CONSTRUCTION OF A RESIDENTIAL FLAT BUILDING CONSISTING OF 130 DWELLINGS WITH BASEMENT CAR PARK AT 61 MOBBS LANE, EPPING

**Environmental Assessment – Residential Development - building 7 and 8 at 61
Mobbs Lane, Epping. (MP 10_018)**

**Re: MP 10_0158 Residential Development- Buildings 7 & 8 at 61 Mobbs Lane,
Epping (former Channel 7 site)**

1 BUILDING 8 LEVEL P1 PLAN
1 : 100

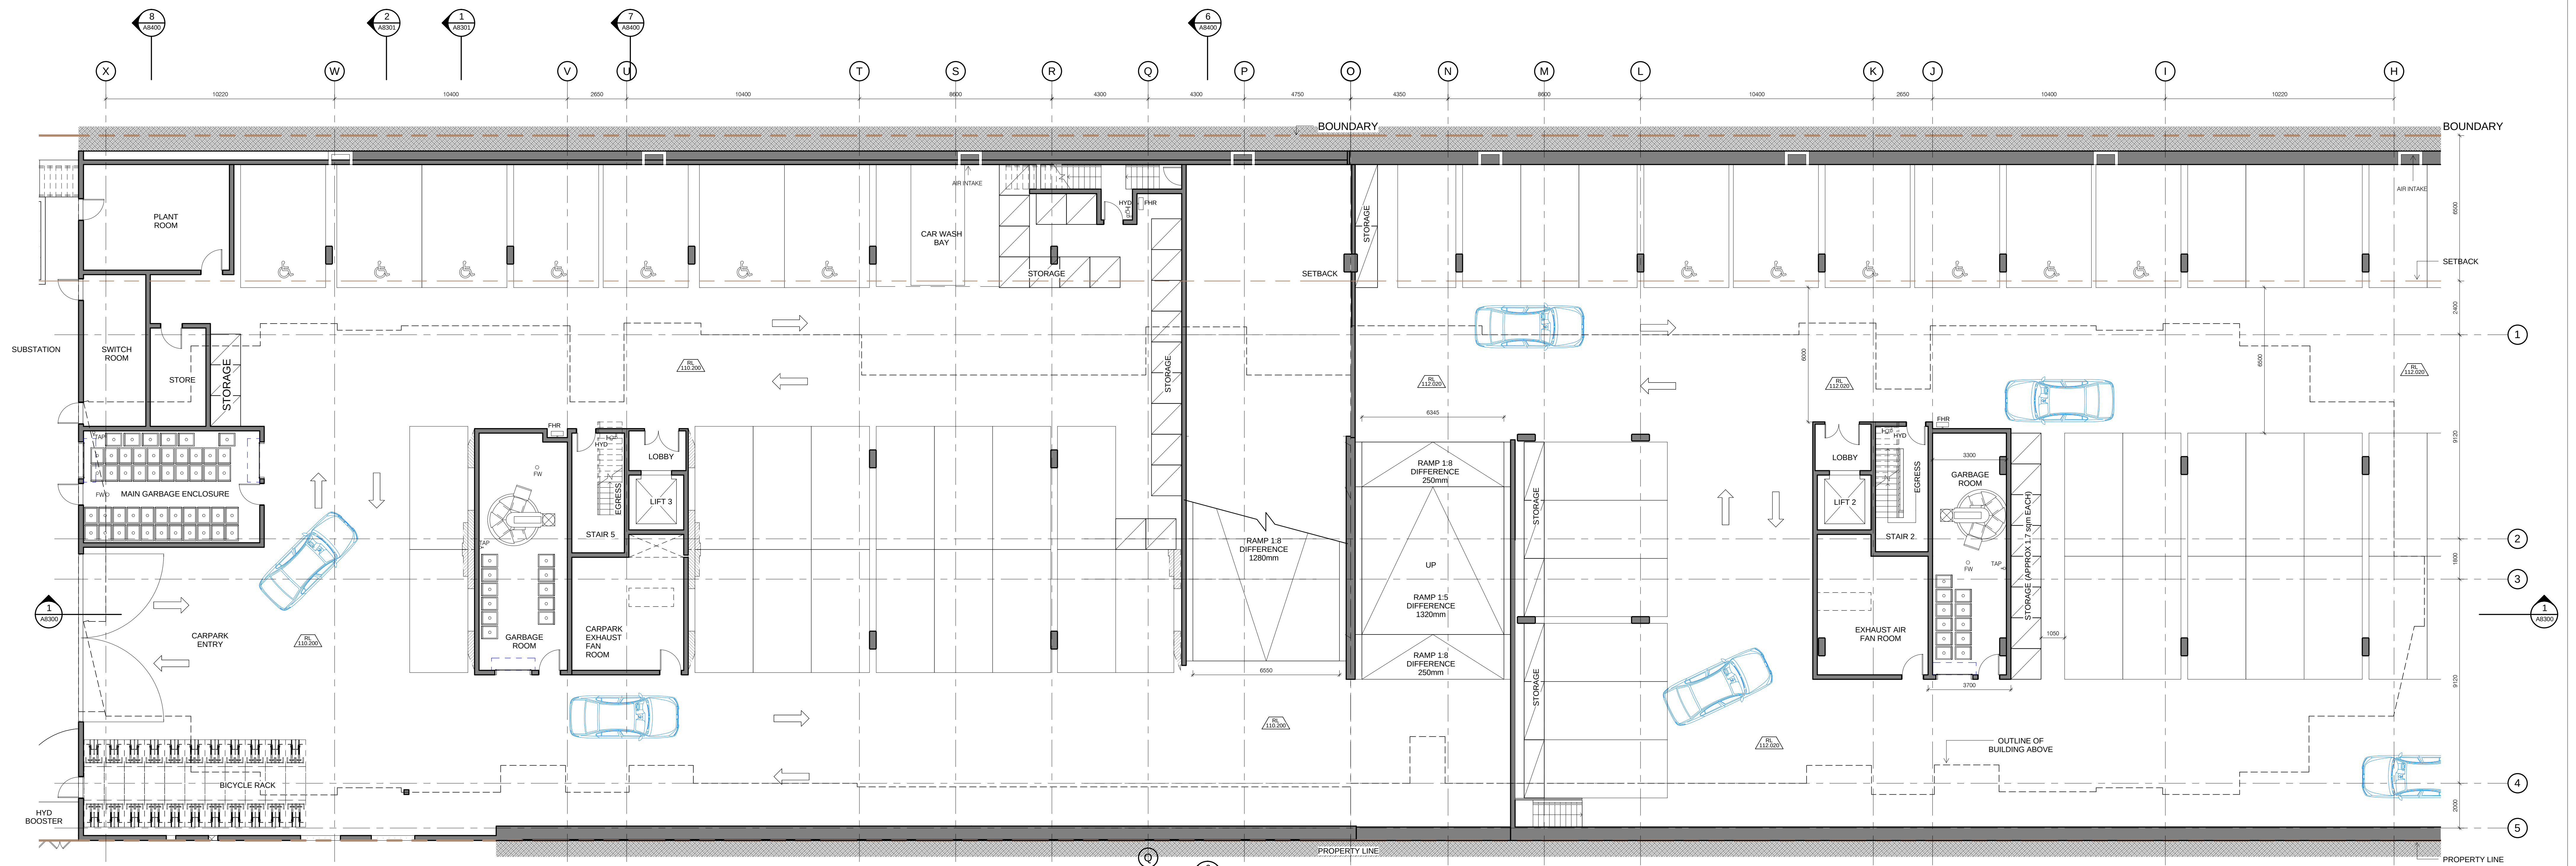
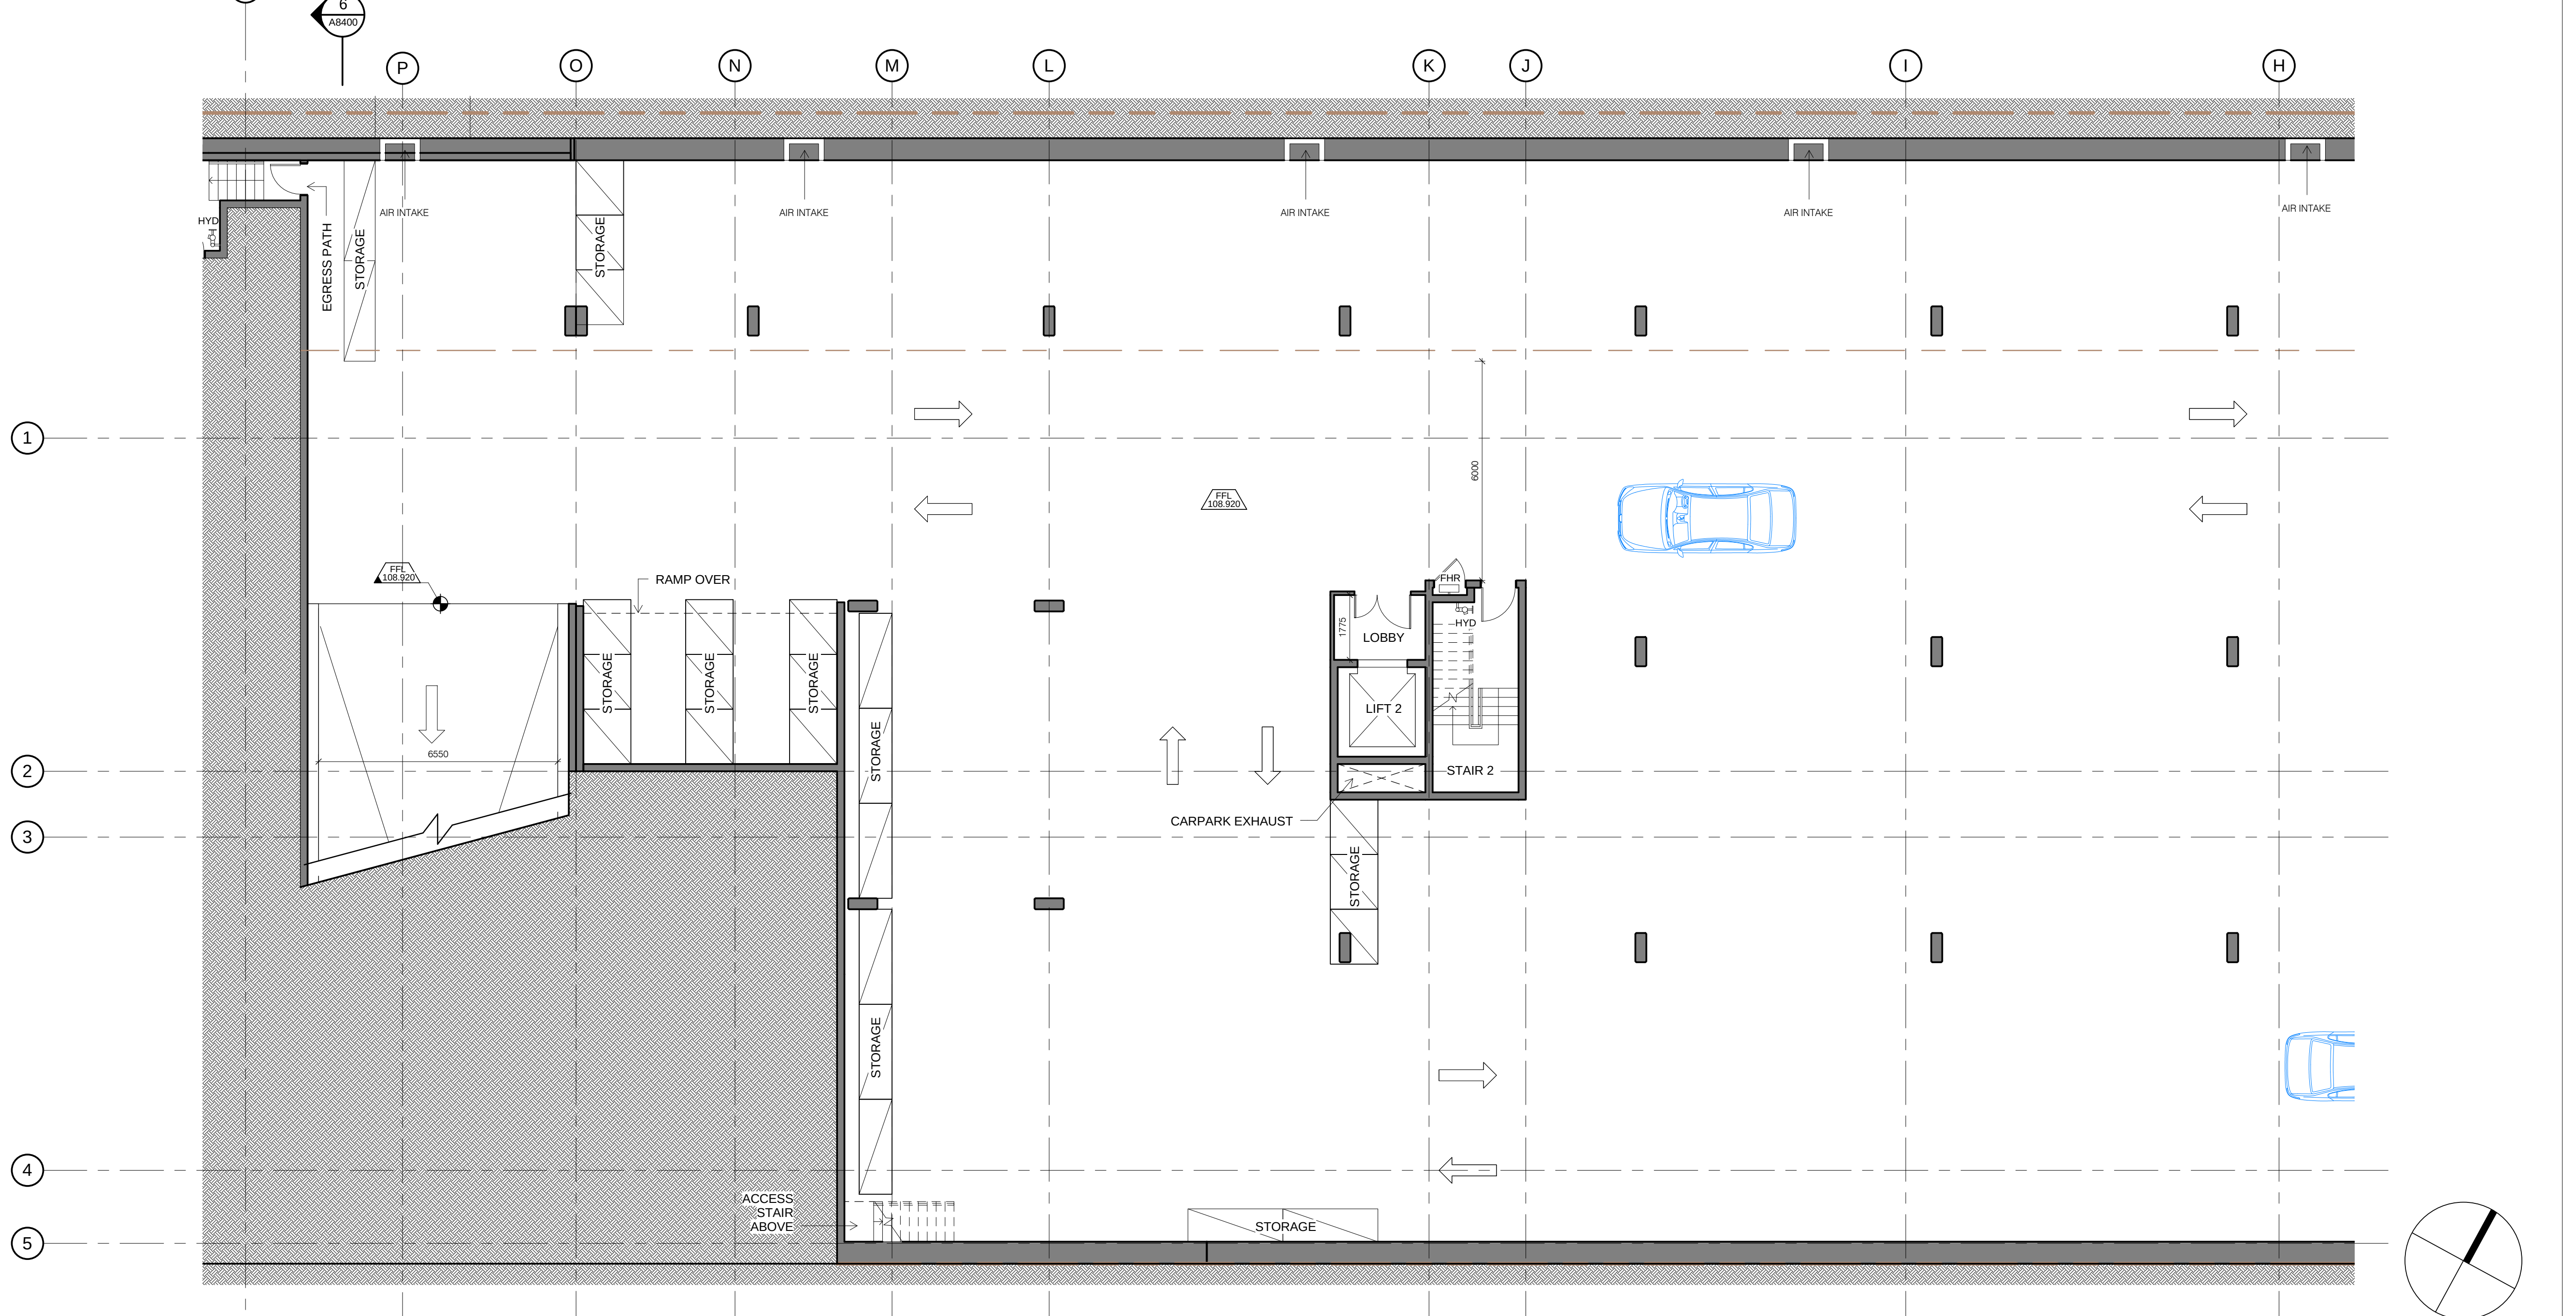
2. It is noted that only one vehicular entry and exit is proposed to service both buildings 7 and 8. It is recommended to provide separate vehicular access points for buildings 7 and 8 to improve traffic safety and efficiency. Providing only one access point for both buildings will discourage the use of underground car park and will result in residence parking in the on-street visitor parking spaces.

3. It is noted that the dimensions of the parking spaces, aisle widths and ramp grades cannot be read from the plans submitted for the subject development application. The DoP should ensure that the layout of the proposed car parking areas associated with the subject development (including, driveways, grades, turn paths, sight distance requirements, aisle widths, aisle lengths, and parking bay dimensions) are in accordance with AS 2890.1 - 2004 and AS 2890 - 2002 for heavy vehicles.

4. The circulation ramps should be to DoP's satisfaction and in accordance with AS 2890.1 - 2004.
5. The turning paths for waste collection vehicles entering the bin collection area have not been shown on the submitted plans. The access road off Road No 2 should be wide enough to ensure that they will accommodate the turning paths of the proposed maximum sized vehicle that will utilise the access when entering and exiting the subject site.

6. Consideration should be given to installing speed humps at regular intervals within the car park to improve safety.
7. The internal aisle ways are to be marked with pavement arrows to direct traffic movements in/out of the site and guide traffic circulation through the car park.

8. The minimum available headroom clearance is to be signposted at all entrances and clearance is to be a minimum of 2.2 metres (for cars and light vans, including all travel paths to and from parking spaces for people with disabilities) measured to the lowest projection of the roof (fire sprinkler, lighting, sign and ventilation), according to AS 2890.1 - 2004.
